Subject: AW/71/18/HH - Queenslawn - proposed elevated obstruction across the verge recommended for approval!

AW71/18/HH – 36 Kingsway – Conservation Area – Objection

Drawing
Arboricultural Impact Assessment,
Arboricultural Method Statement

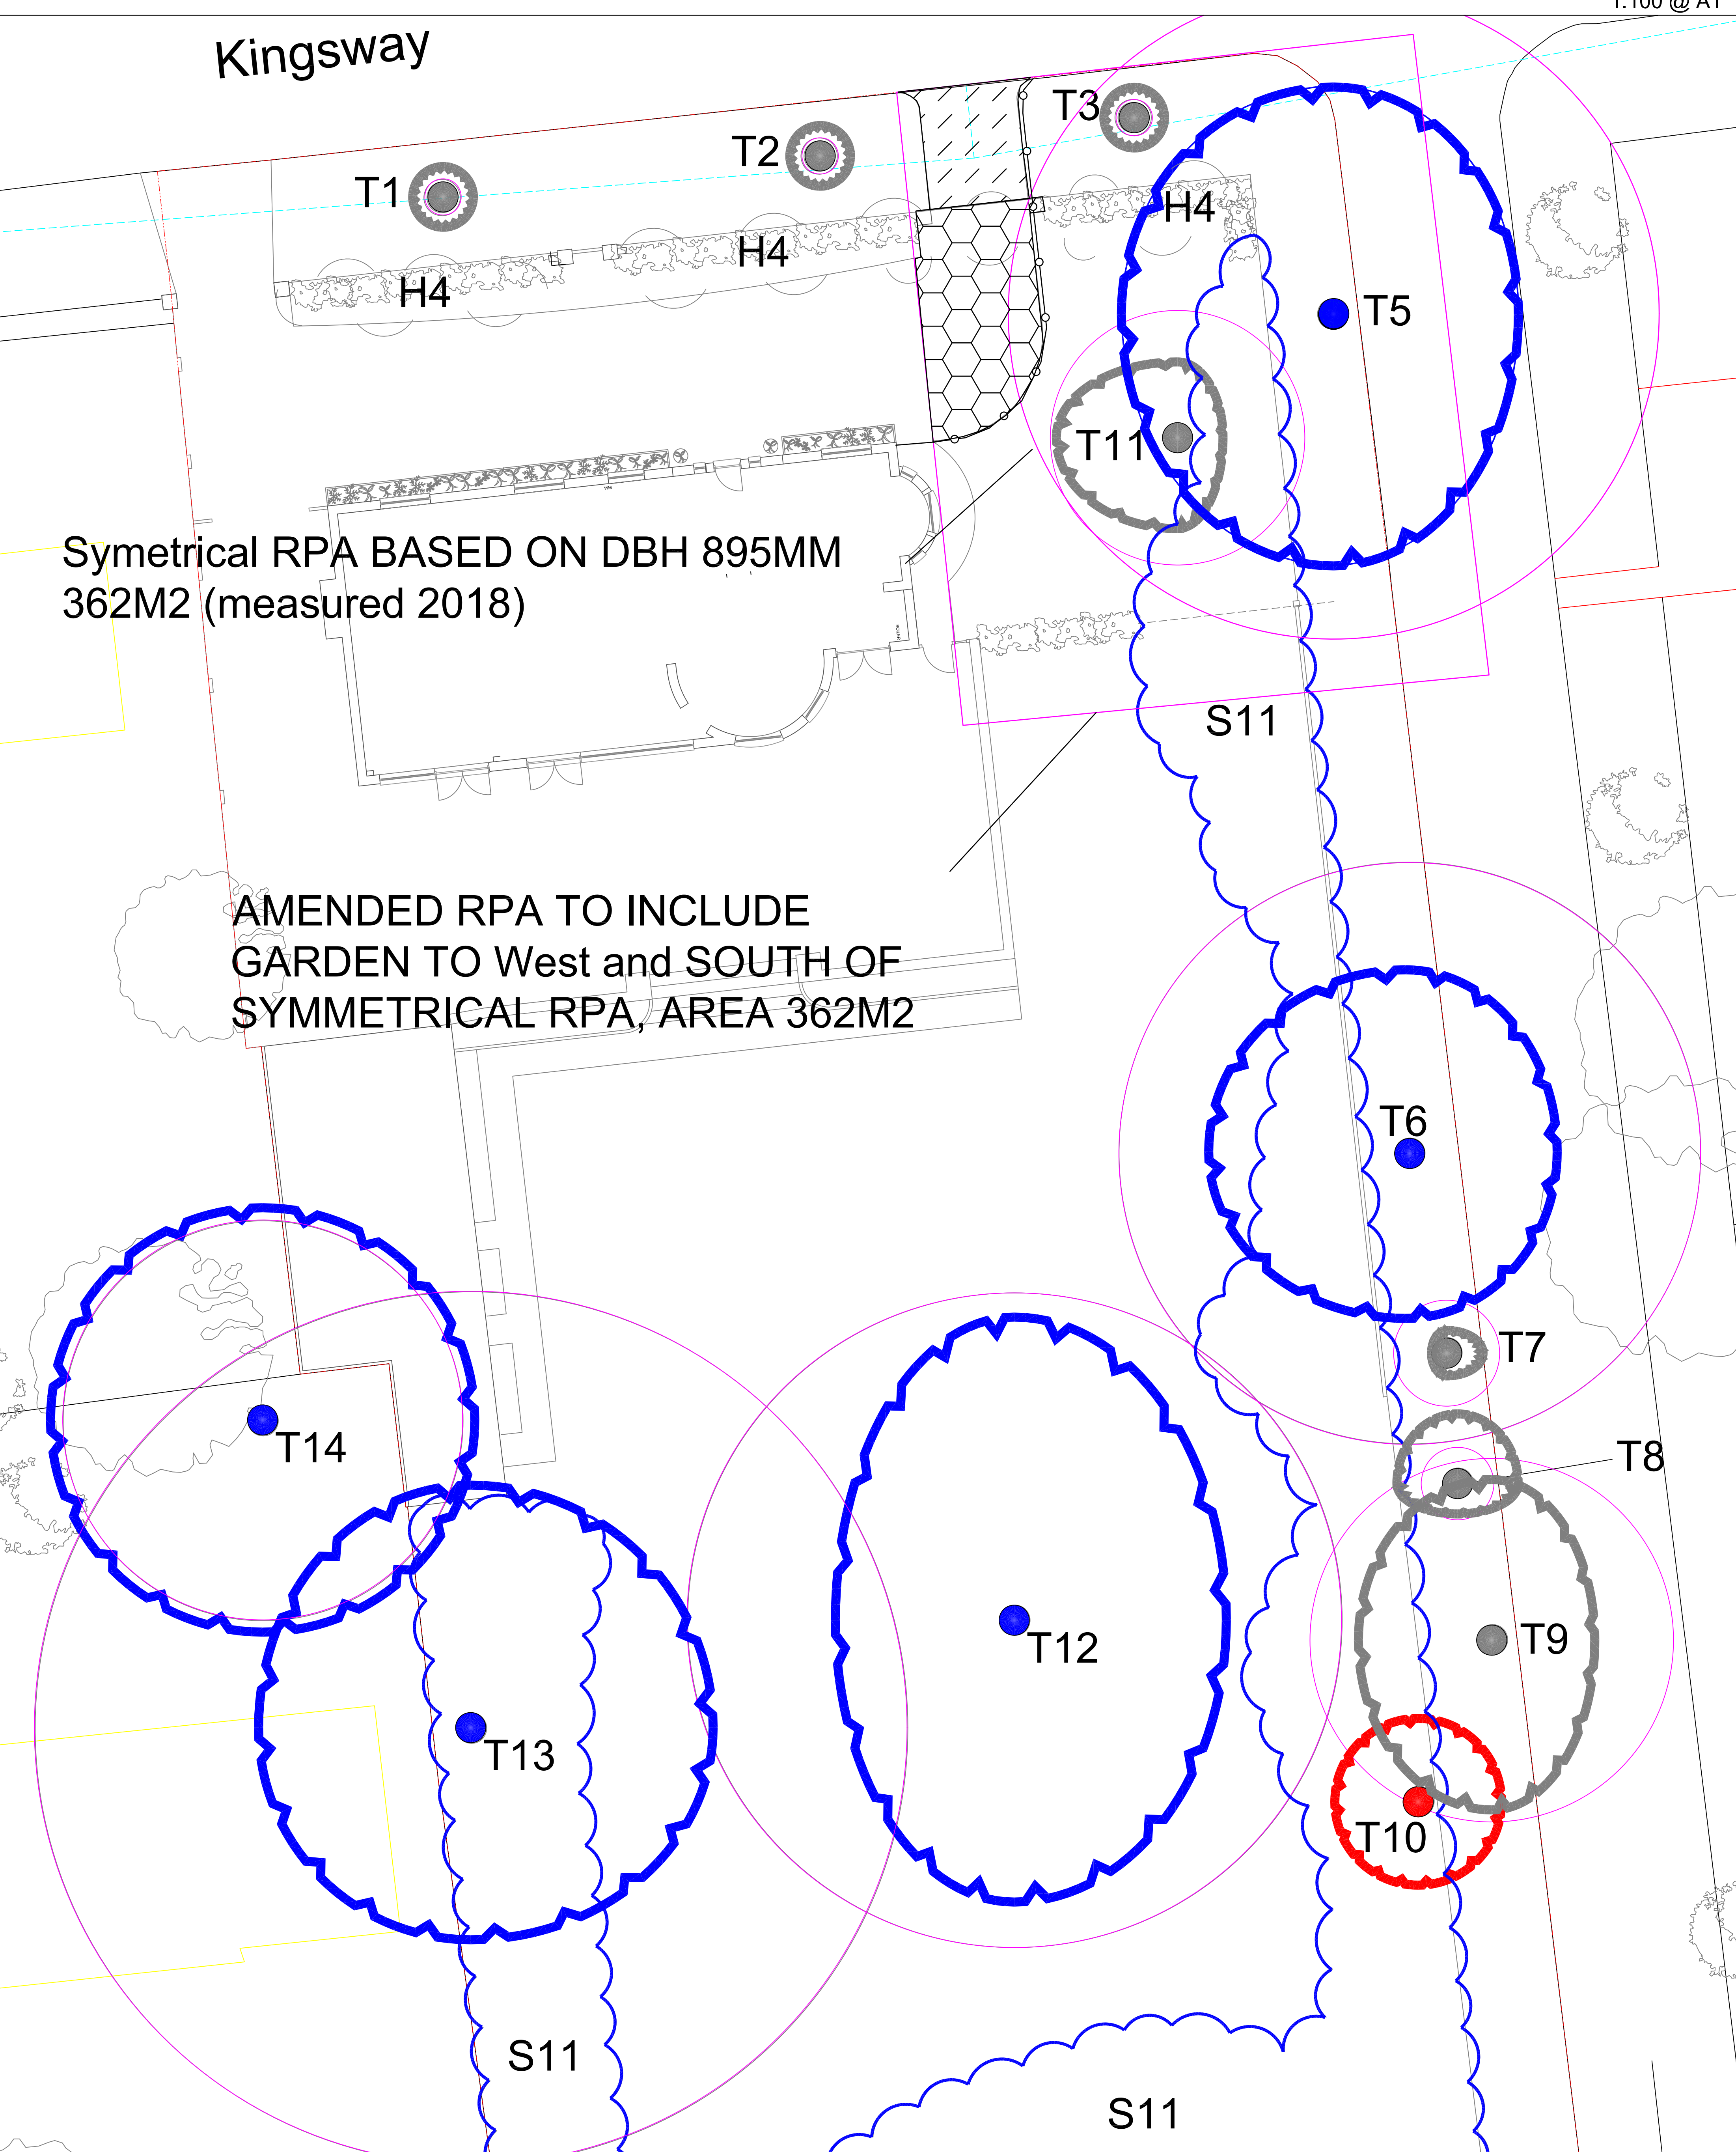
Seriously significant issues, from an experienced engineer, explain that the verge will now be rained by 200mm (8") minimum from the verge up to the first rung of the boundary fencing. The system, composed of blockwork, shingle, sand etc will then be held in position by 20mm (3/4") wide timber – undoubtedly shuttering plywood – and that will be held by 15mm (1/2")_ timber pegs. SO, there will be a raised ramp across the verge from the road to the boundary – and gated opening outwards on top of this!

This latest aspect is, clearly, ludicrous, as explained by Mr. Bremner. Is it not time for an Engineer to consider this aspect and for a Consultant Arboriculturalist to give a second opinion on the protection of the roots and T5?

TITLE
**Cellweb Section - Tree Root Protection
c/w Block Paving Surface**

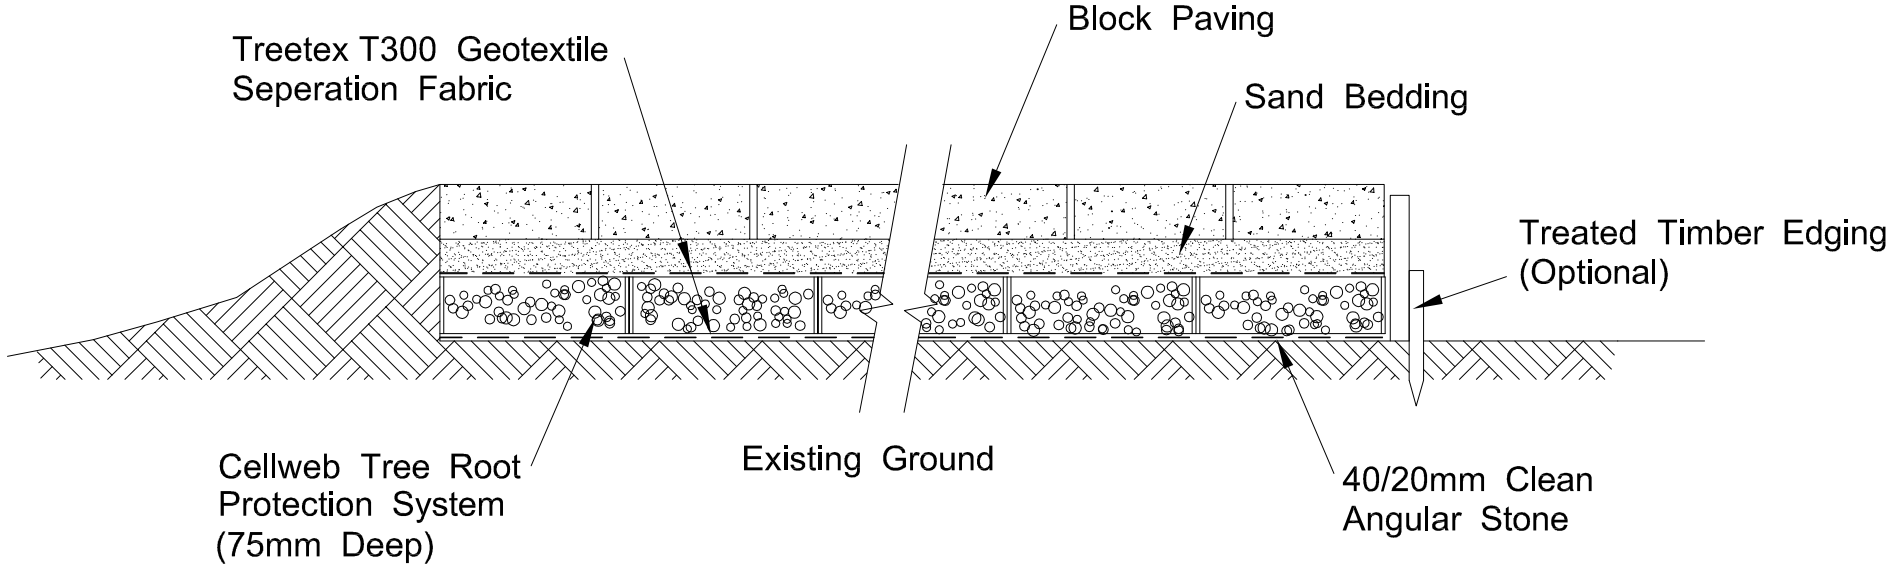
Paragraph 8.2, referring to one of the two areas within the root protection area, includes: 'The area of driveway adjacent to Kingsway will be excavated by hand to enable a dropped crossing to be constructed, the extent of the excavation will vary as it progresses towards the garden boundary where it will have reached the existing ground level.' Later in the same paragraph 'The construction will then be carried out using the principles set out in the typical construction detail shown in the Geosynthetics drawing for cell web no dig construction as illustrated in the architects drawing.'

In other words the cell web construction will sit on top of a slope from about 20cms below the existing gutter to the present ground level at the Queenslawn boundary. The system, according to the drawings is 20 cm thick, so there will be a slope, across the grass verge, from the present gutter level to 20cm above the present ground level at the curtilage boundary, roughly equivalent to the top of the existing fence gravel boards.

On the eastern side this ramp is shown as vertical and supported by 20mm wooden boarding secured by vertical 15mm wooden stakes.

Also one wonders about the stability of such a structure with traffic passing over it. It looks extraordinarily flimsy.

Do you envisage the need for railings to prevent the postman or anyone else from either tripping over the ramp or falling off it?

Will the excavations below the gutter have any effect on the road foundations?
